Recommendation Report for Planning Permission for Works or Extension to a Dwelling

REF NO: BR/117/22/HH

LOCATION: 82 Victoria Drive
Bognor Regis
PO21 2TA

PROPOSAL: Erection of part first floor extension over existing ground floor including part two storey element to rear with Juliette balcony to front elevation, widening of drop kerb and replacement boundary wall.

Proposed Elevations

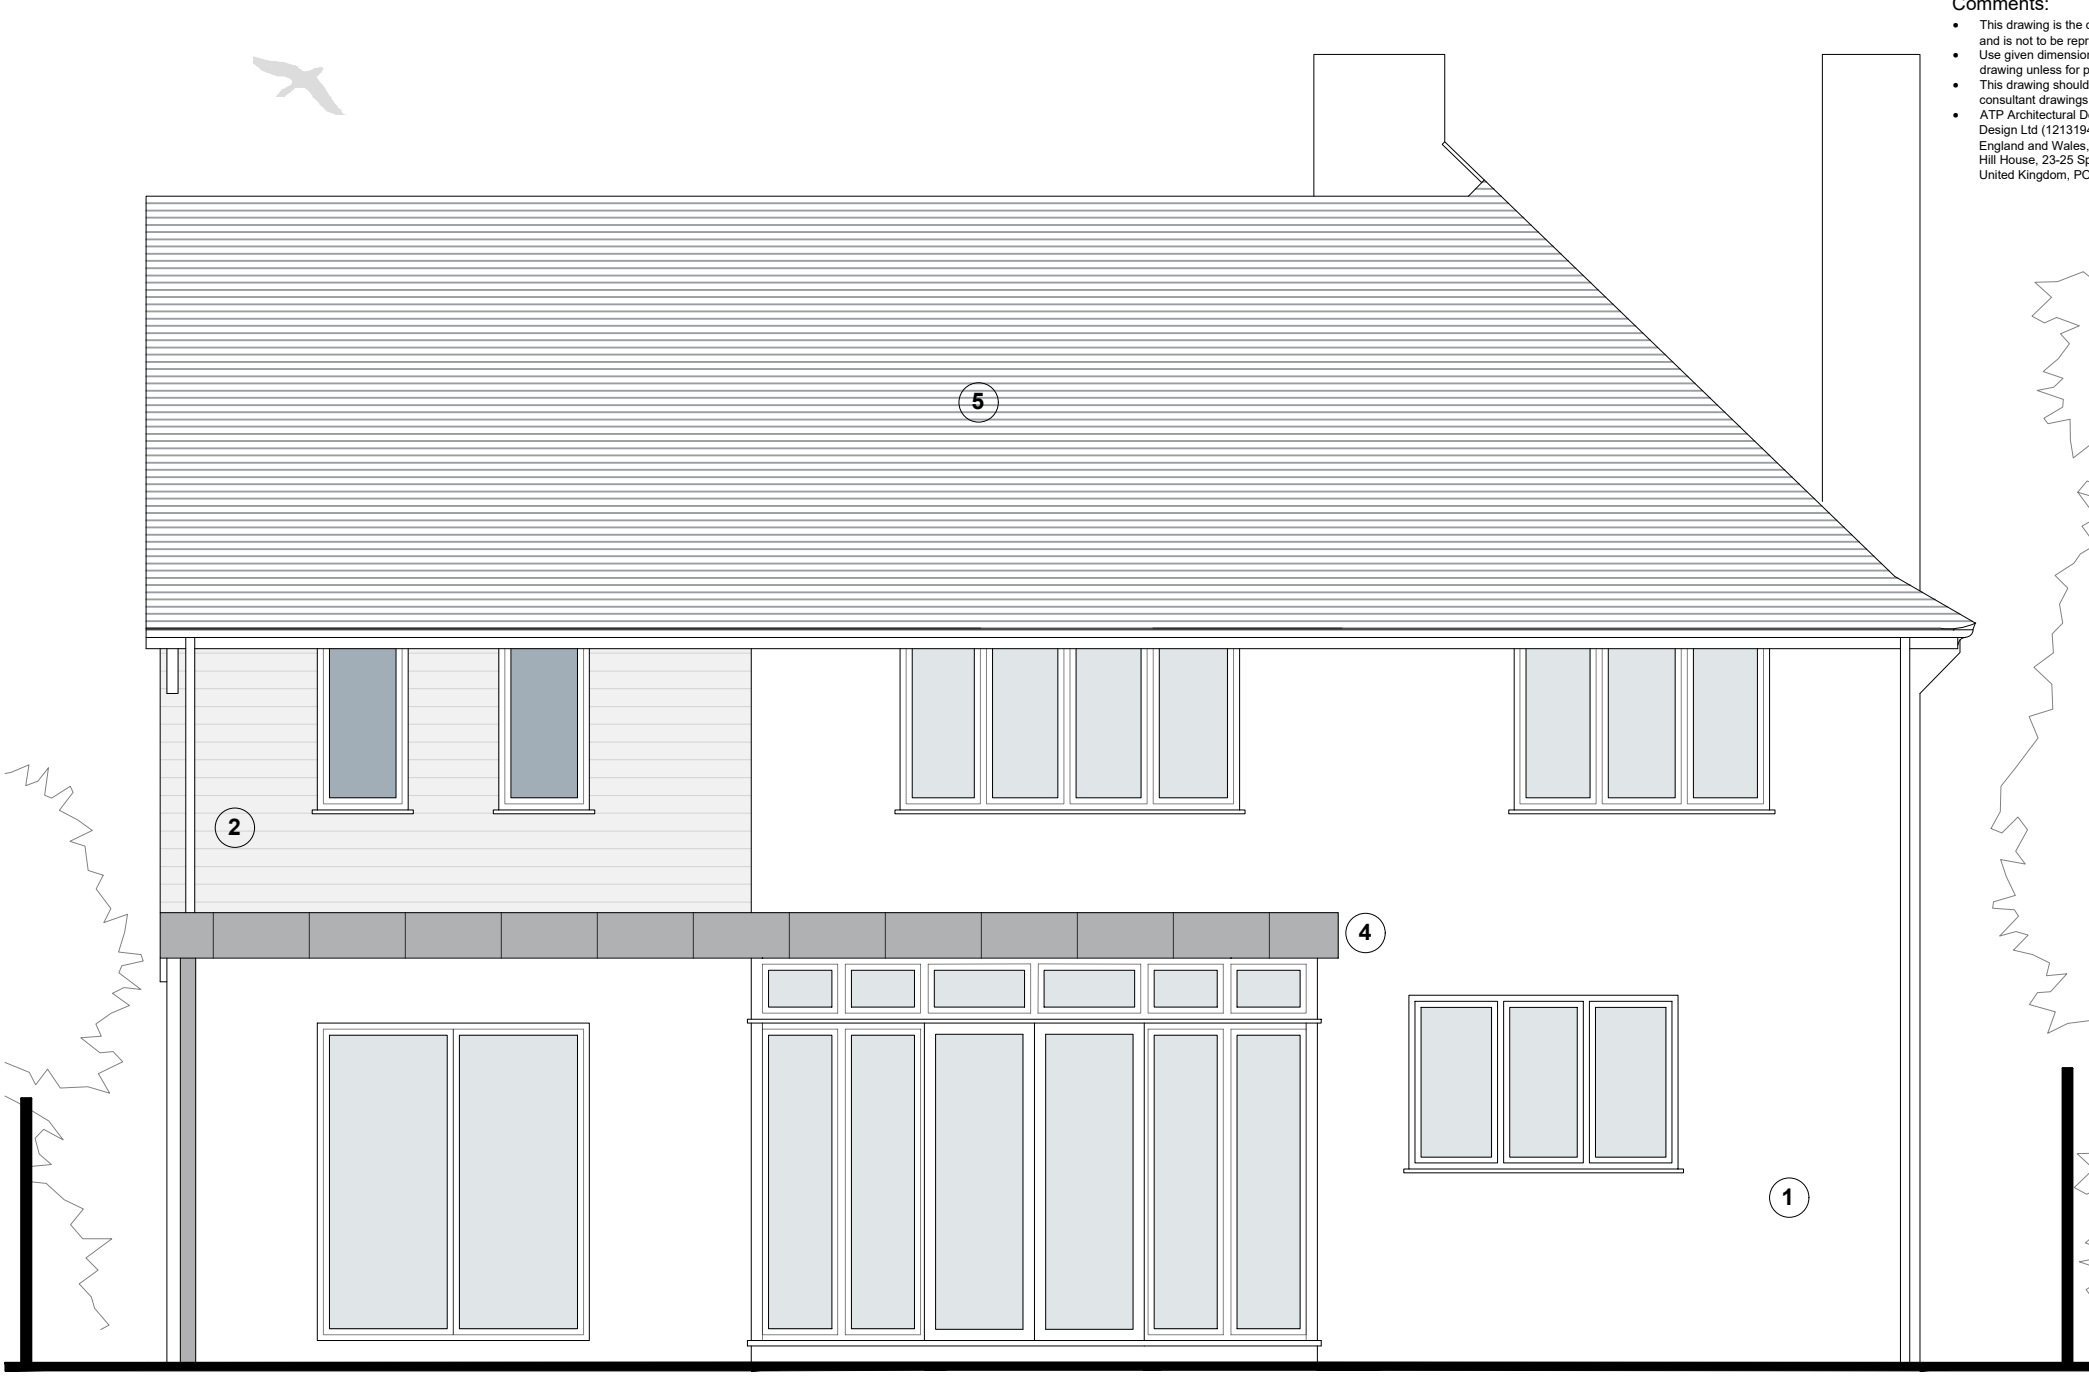
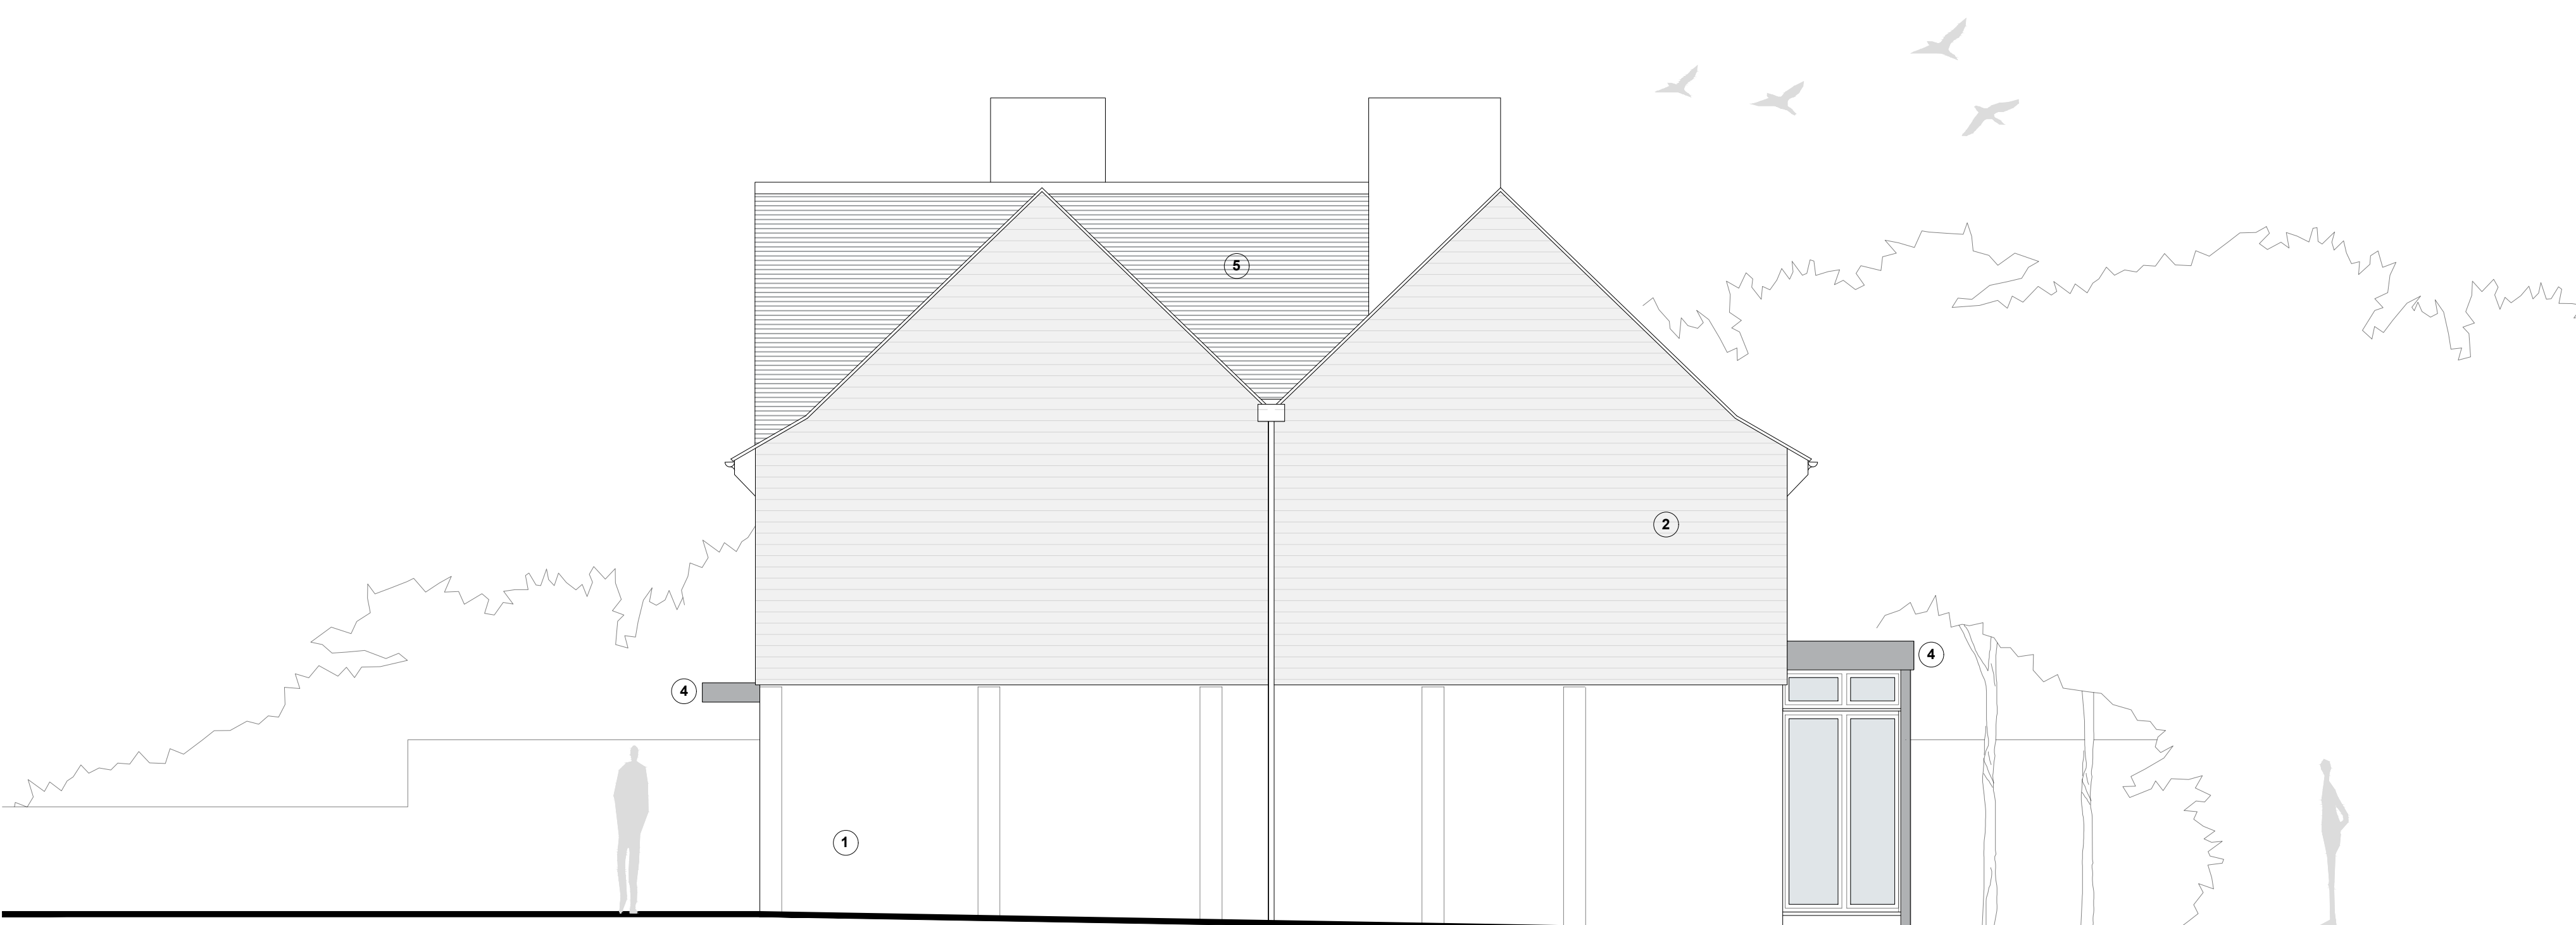
The development appears well integrated featuring a pitched roof matching that of the host dwelling.

External materials will feature white render and grey cladding. Whilst cladding is not common within the street scene, the use of these materials is acceptable and will not result in harm upon the street scene.

The Arun Design Guide states 'Side extensions should be set back from the front of the house in order to play a subservient role'. 'Extensions must not close important gaps in the street scene by leading to a terracing effect or remove existing external access from front to back gardens. This can generally be ensured by keeping extensions at least 1 metre away from the side boundary of a plot at ground floor and 2 metres away at first floor and above'. The proposal conflicts with the guide in that the extension is not set back although it is situated above an existing ground floor addition and is acceptable. The extension also does not retain 2m at first floor level, although does not result in a terracing effect.

No side facing windows are proposed. There will be 2 additional first floor rear facing windows although these will serve bathrooms and will likely be obscured glazed. Views achievable from these would be over neighbouring gardens although none into direct windows. To the front, there will be a Juliet balcony. This will provide views over the street scene. To the ground floor rear there will be some alterations to fenestration although this will not give rise to overlooking being a ground floor level, views are predominately across the garden of the host dwelling. 28m is retained to the rear boundary which has planting to restrict views towards the flats to the rear of the site.
